From: Simon Davis
Sent: 30 June 2022 12:16
To: 'Lucy Anderson' [REDACTED]
Cc: 'Michelle Quan' [REDACTED]
Subject: RE: MWPA Response AL-49-22-PL

As per our discussion, the issues I identified versus the Design Guide were:

TITLE
Plots 35 - 37
Proposed Plans & Elevations

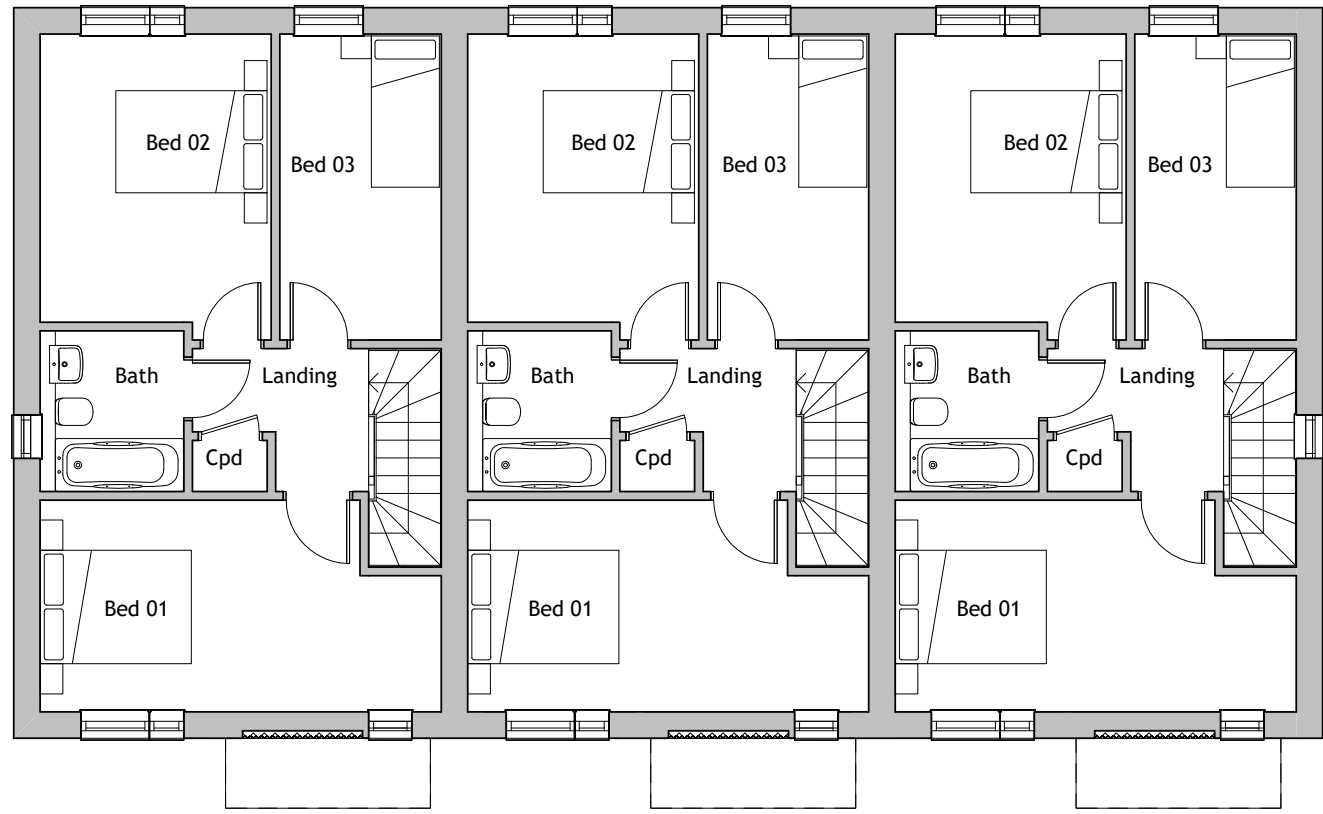
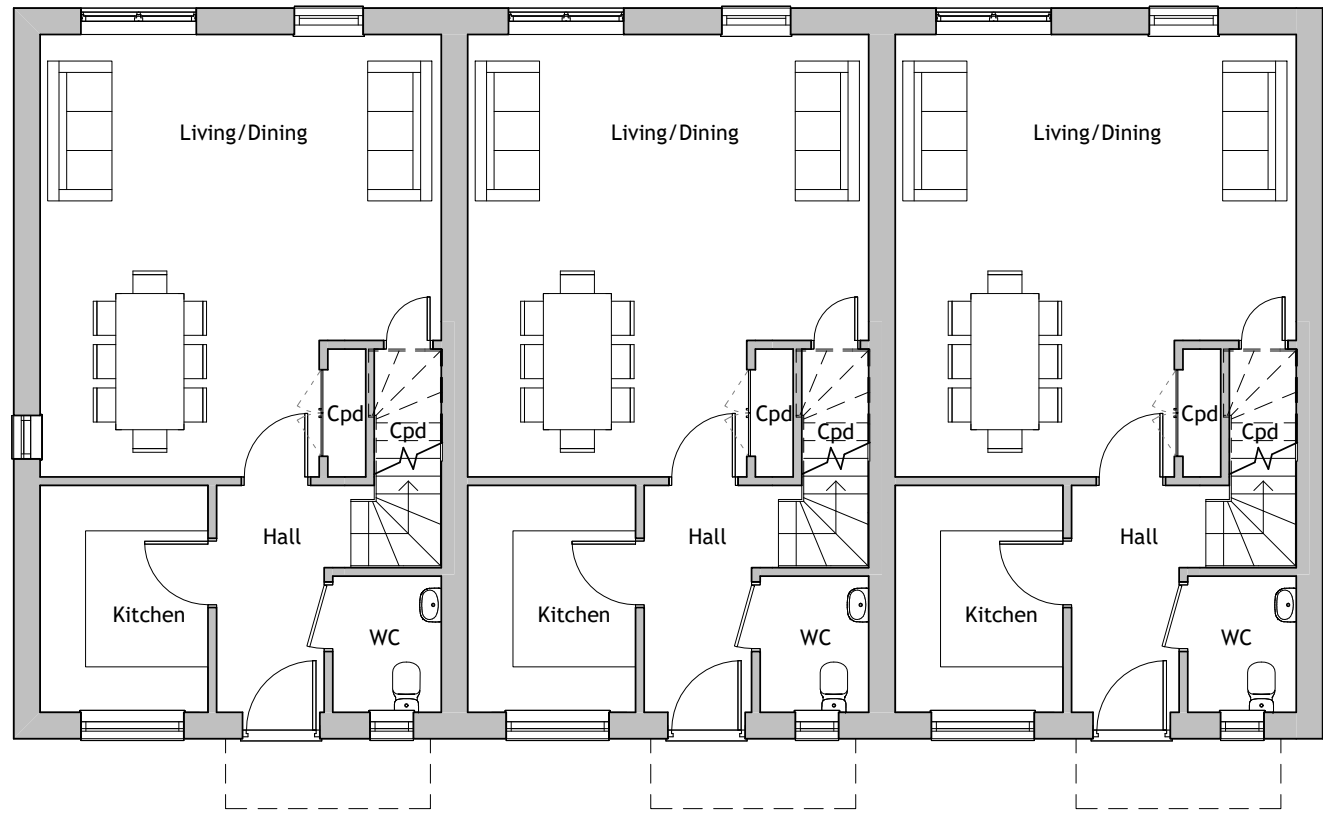
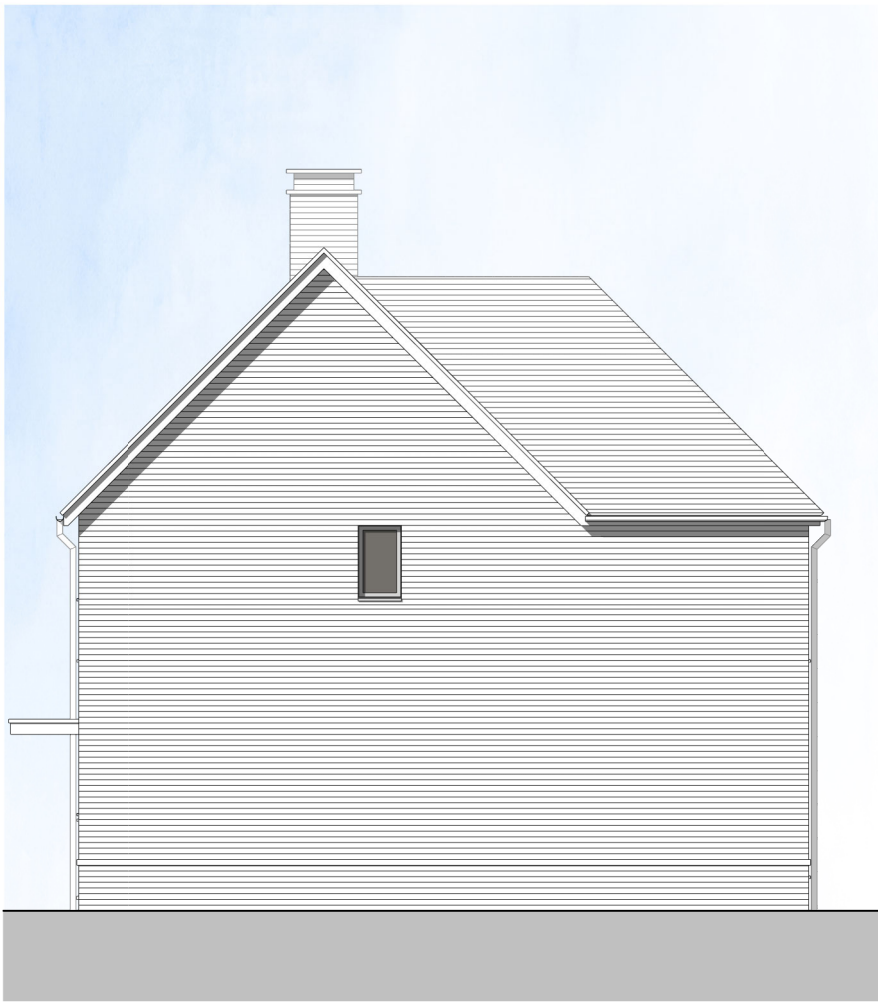
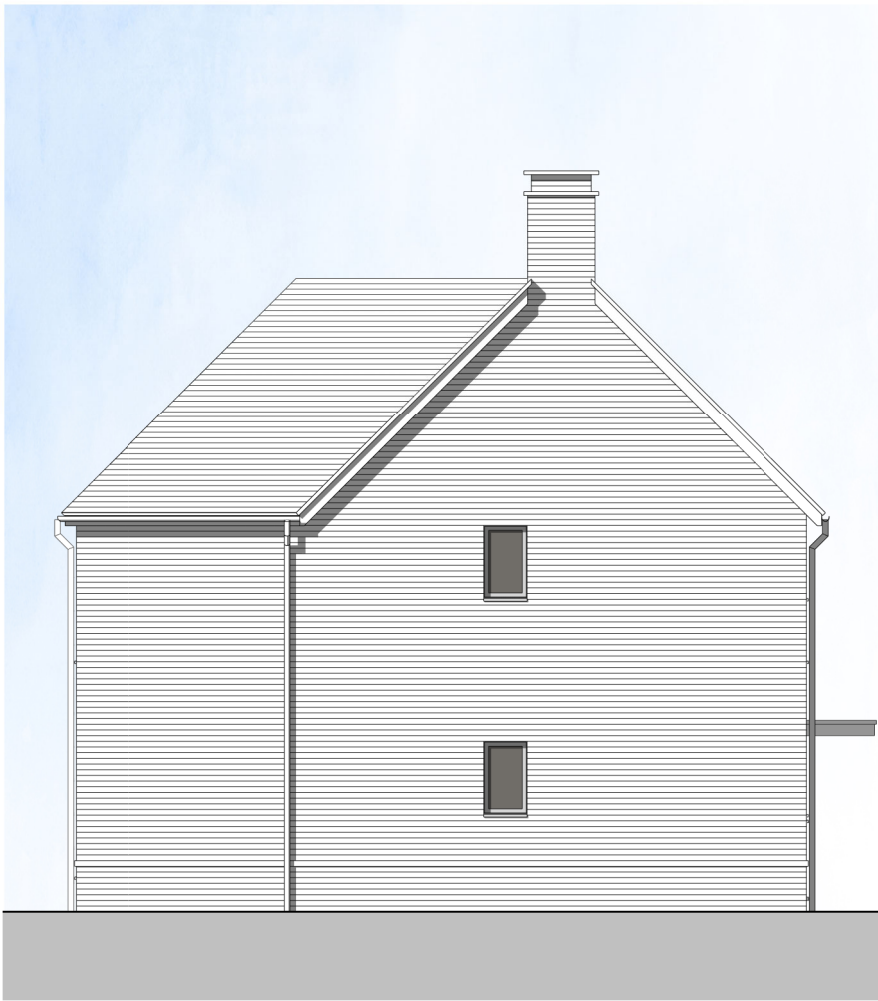
The relationship at (7) is quite concerning and although the ADG is guidance, we would not be able to sanction shortfalls of more than say 0.5m unless there are no windows involved or they are o/g and non/restricted opening (although the standards are also there to protect the amenity of gardens). Talking of o/g, we would want to see the western flank windows on plots 37 and 21/22 as o/g and restricted or non-opening.

TITLE
Plots 42-43, 63-64, 65-66
Proposed Plans & Elevations

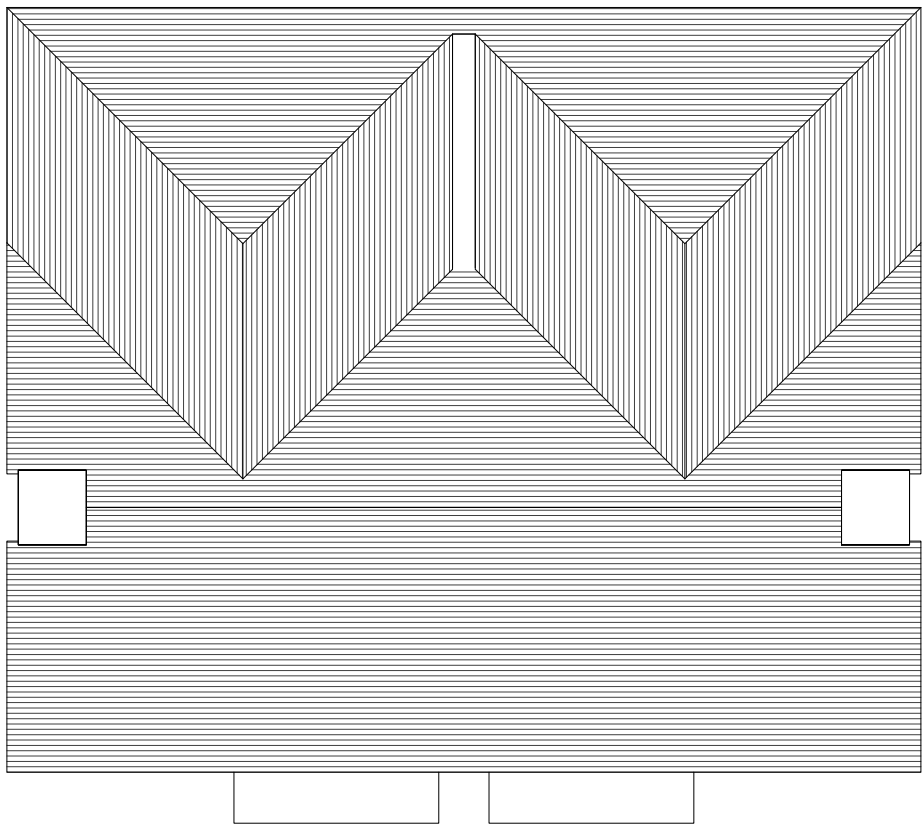
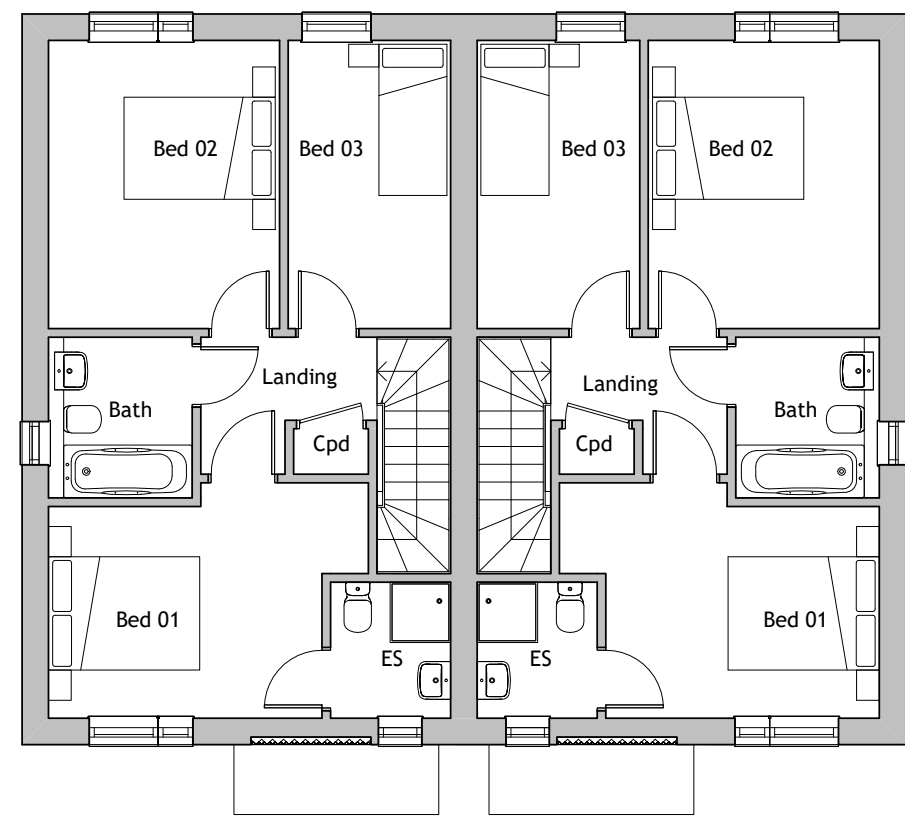
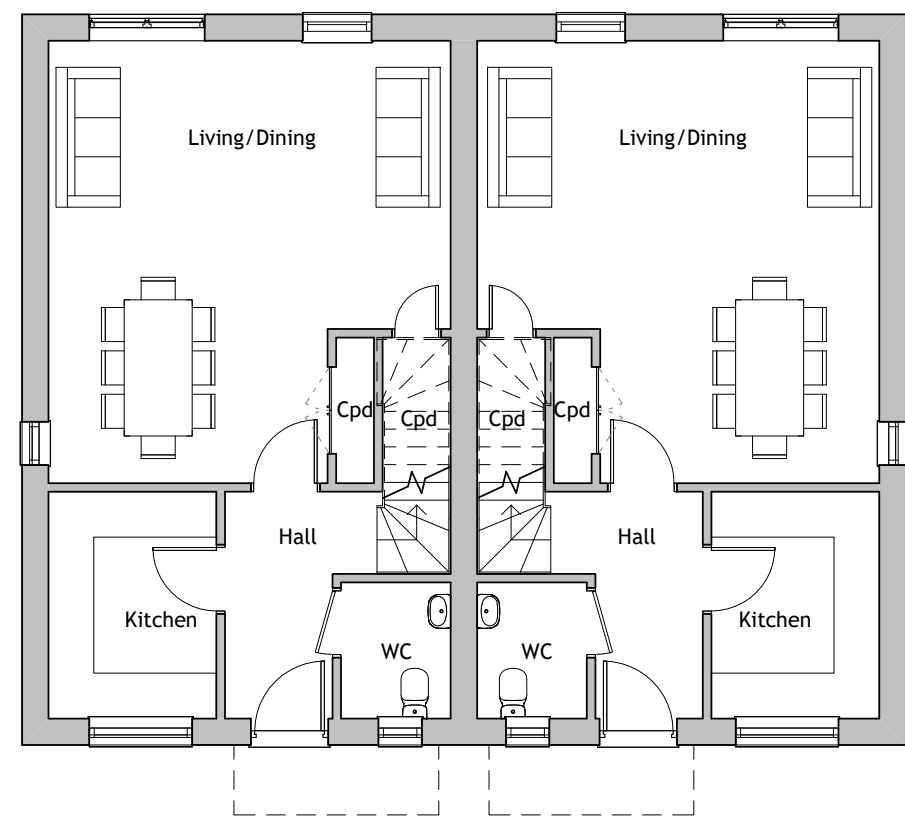
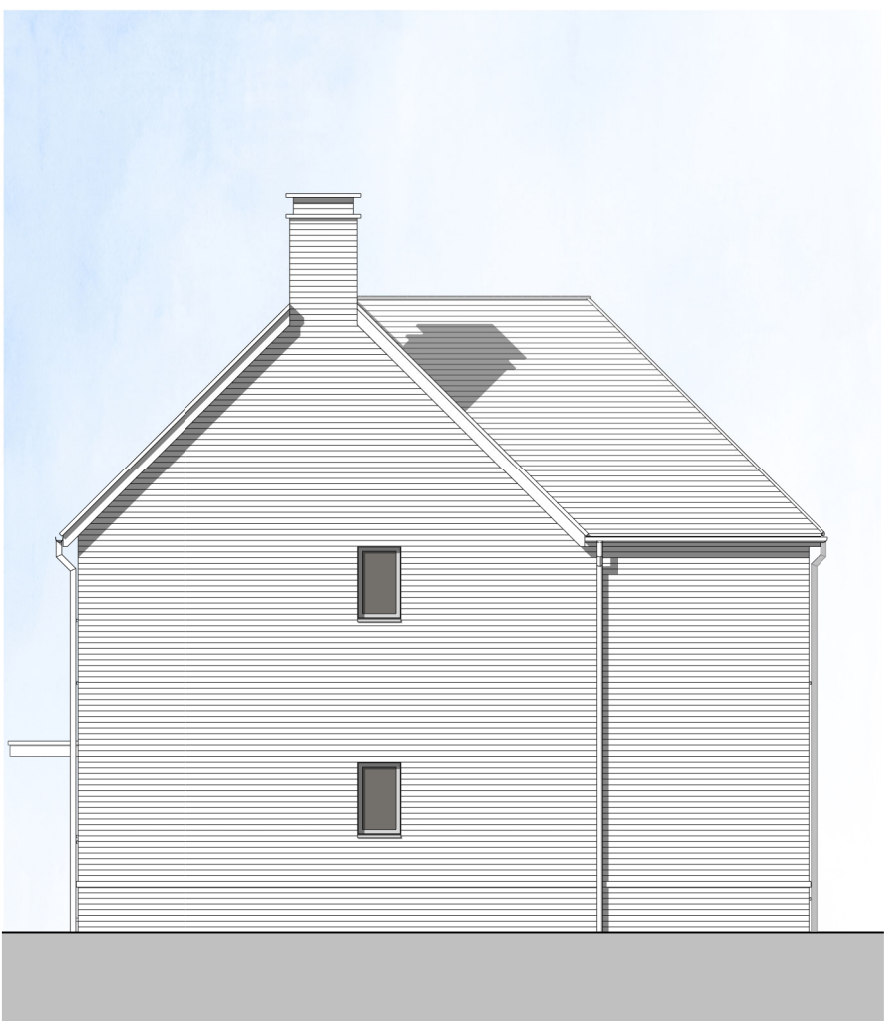
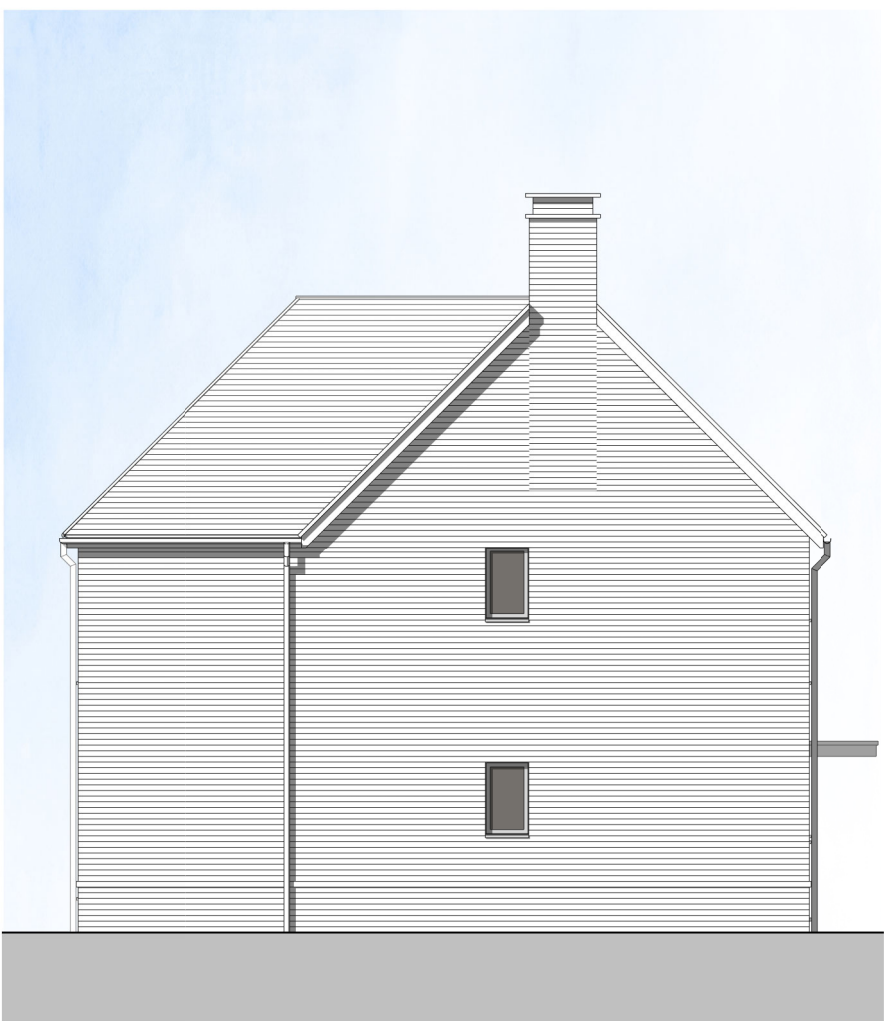
- (1) 9-13 Front (F) to 15 F is 13.5m (16m requirement)
- (2) 9-13 F to 14 F is 15m (16m)
- (3) 32 F to 41 F is 14.5m (16m)
- (4) 74/75 F to 51-58 F is 15m (16m)
- (5) 44 Rear (R) to 45 Side (S) is 13.5m (14m)
- (6) 41 R to 40 S is 11m (14m)
- (7) 21/22 R to 36/37 R is 15.5m (21m)
